From: Simon Davis
Sent: 06 August 2021 16:45
To: Adrian D'Cruz [REDACTED]
Subject: RE: Planning Consultation on: AW/228/21/RES

I have reviewed the application in full and pretty much everything is fine. The only issue I have (notwithstanding the landscaping plan request) is in terms of parking provision.

Parking Plan at 1:500 scale
WITH SWEEP PATH (ACCESS) OVERLAY

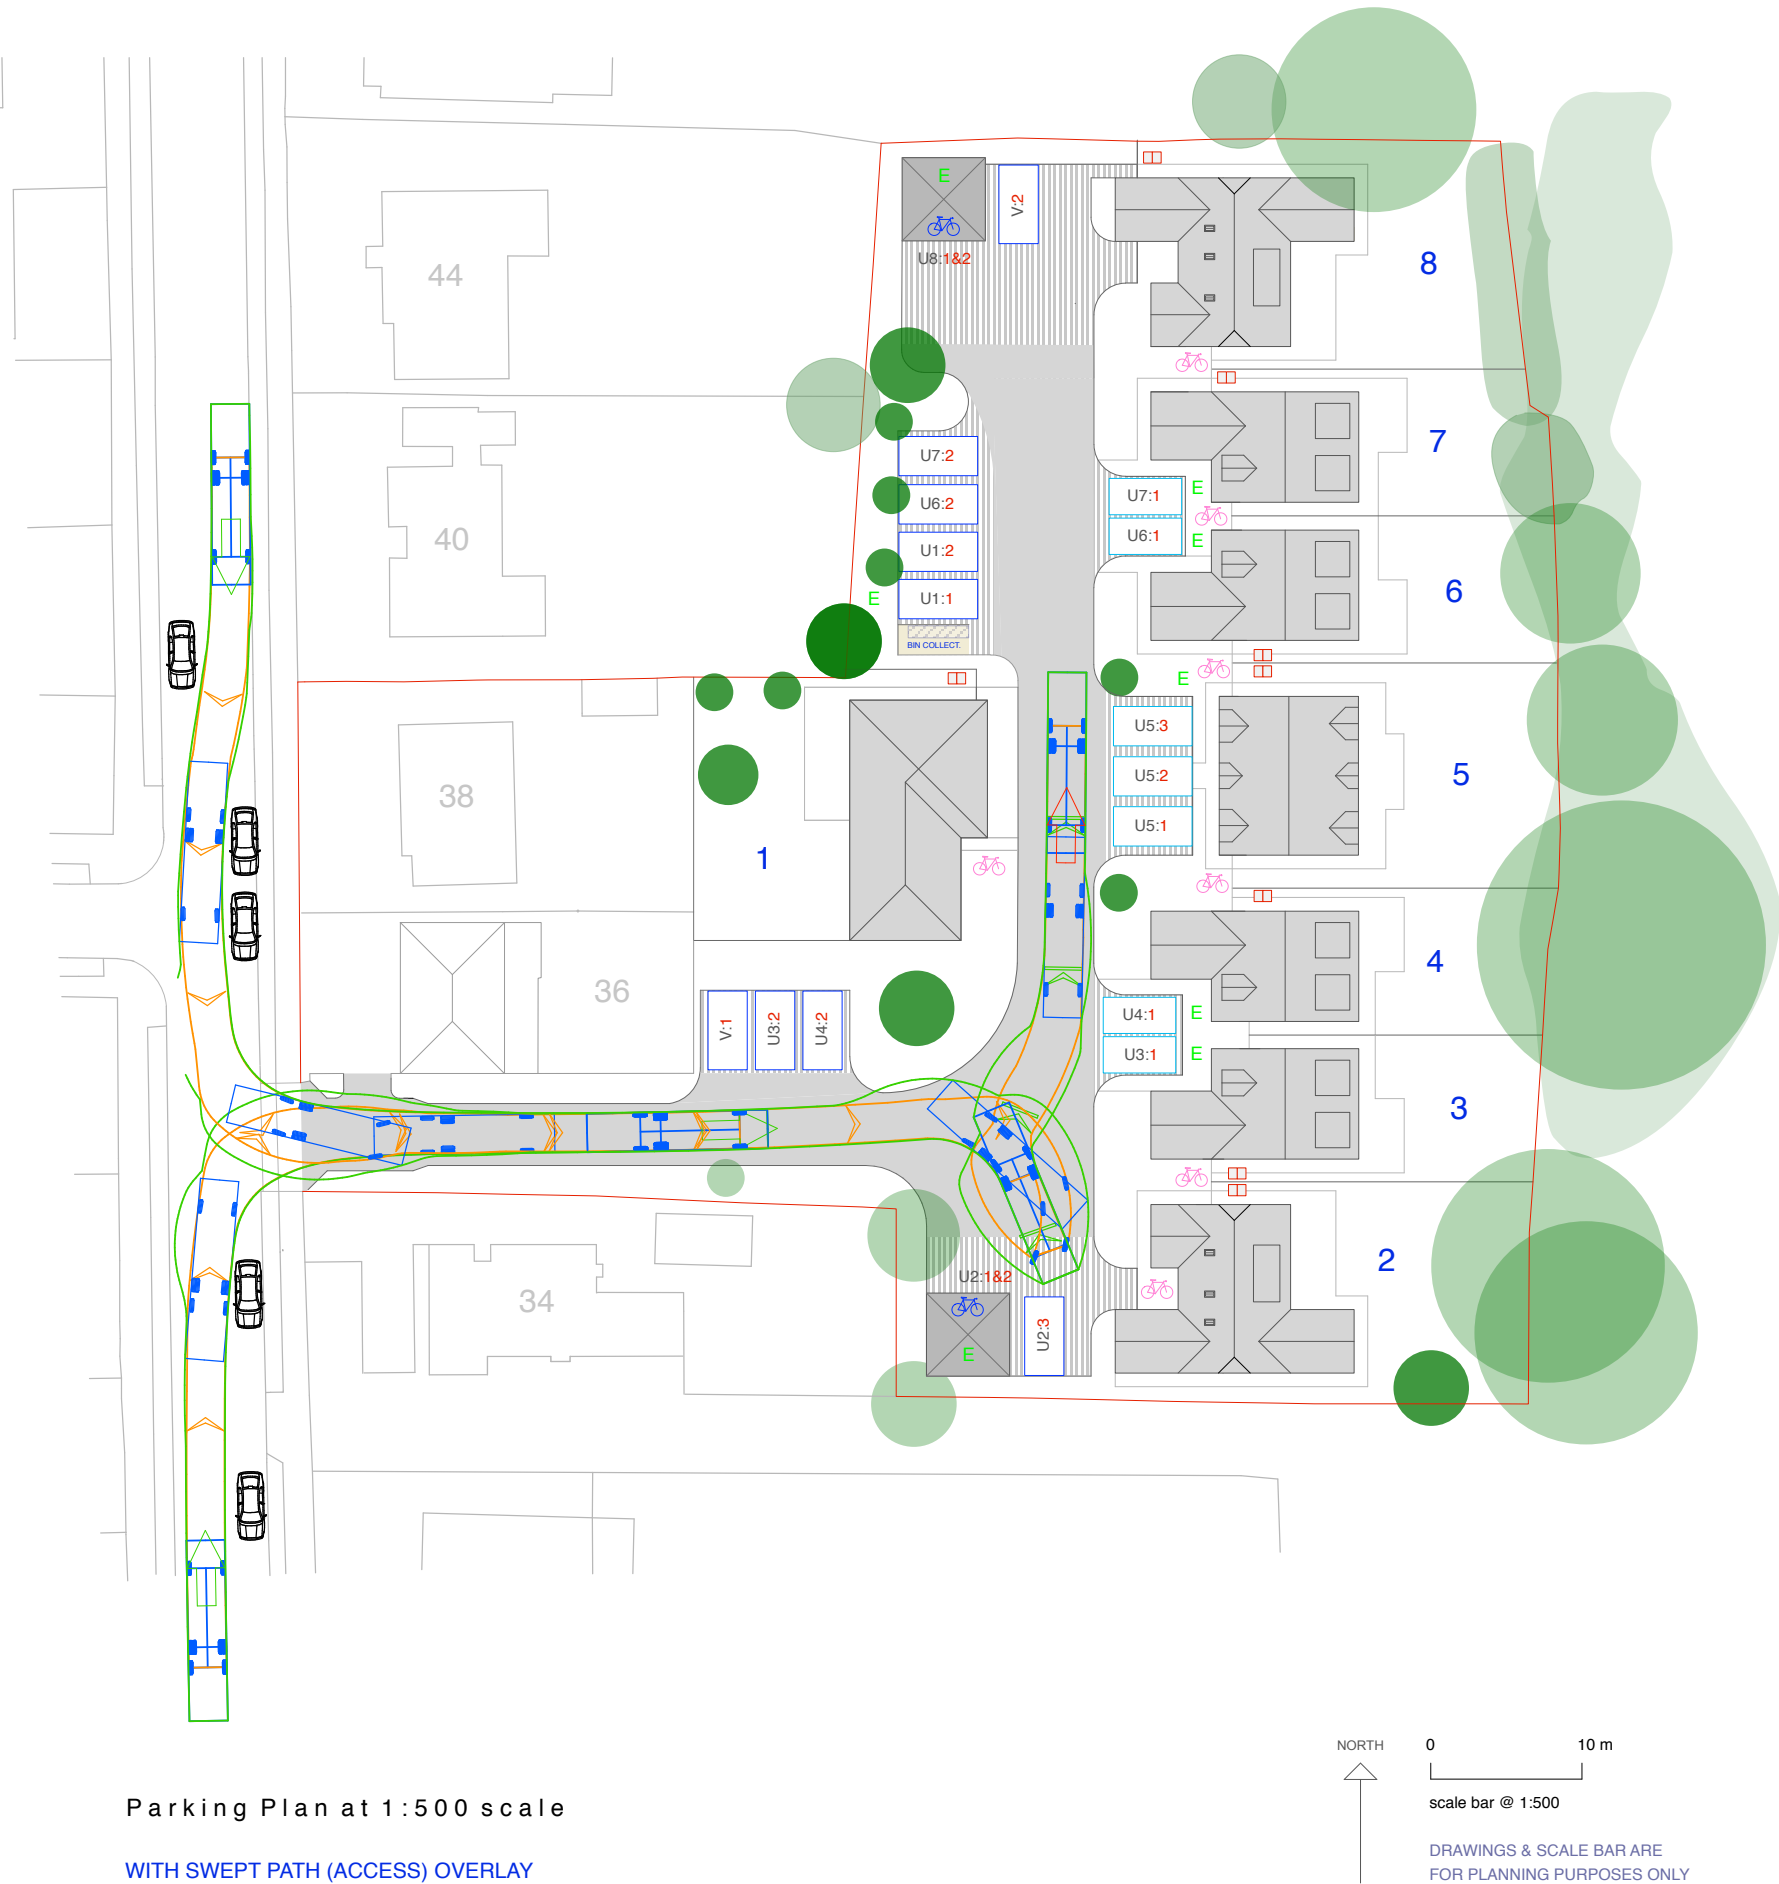
Our Parking Standards SPD requires 19 spaces including 2 visitor. You show 18 and 2 visitor but 4 of these are in double garages. The issue is that our SPD states that garage spaces must be 3 x 6m (single) to be counted as half a space and that if not meeting these dimensions they will not be counted at all. There are no floor or elevation plans for the garages (this itself is an issue) but I measured from the layout plan and the garages seem to be 5.5m by 5.5m so are undersized. As each garage only serves one dwelling, I will count them as providing half a space each but this leaves you short by 2 spaces versus the requirements.

If you increase the garage dimensions to 6m by 6m then I can treat them as having 1 space each (2 x 0.5 each) but this still leaves you short of the requirements. Therefore, I suggest that you change the garages for double car ports as that way I can treat them as having 2 spaces each. If you agree, then I will need plans & elevations of the car ports. If you also need to amend the dimensions of the structure then I will also need other plans amending to show this (layout, landscaping, parking plans).
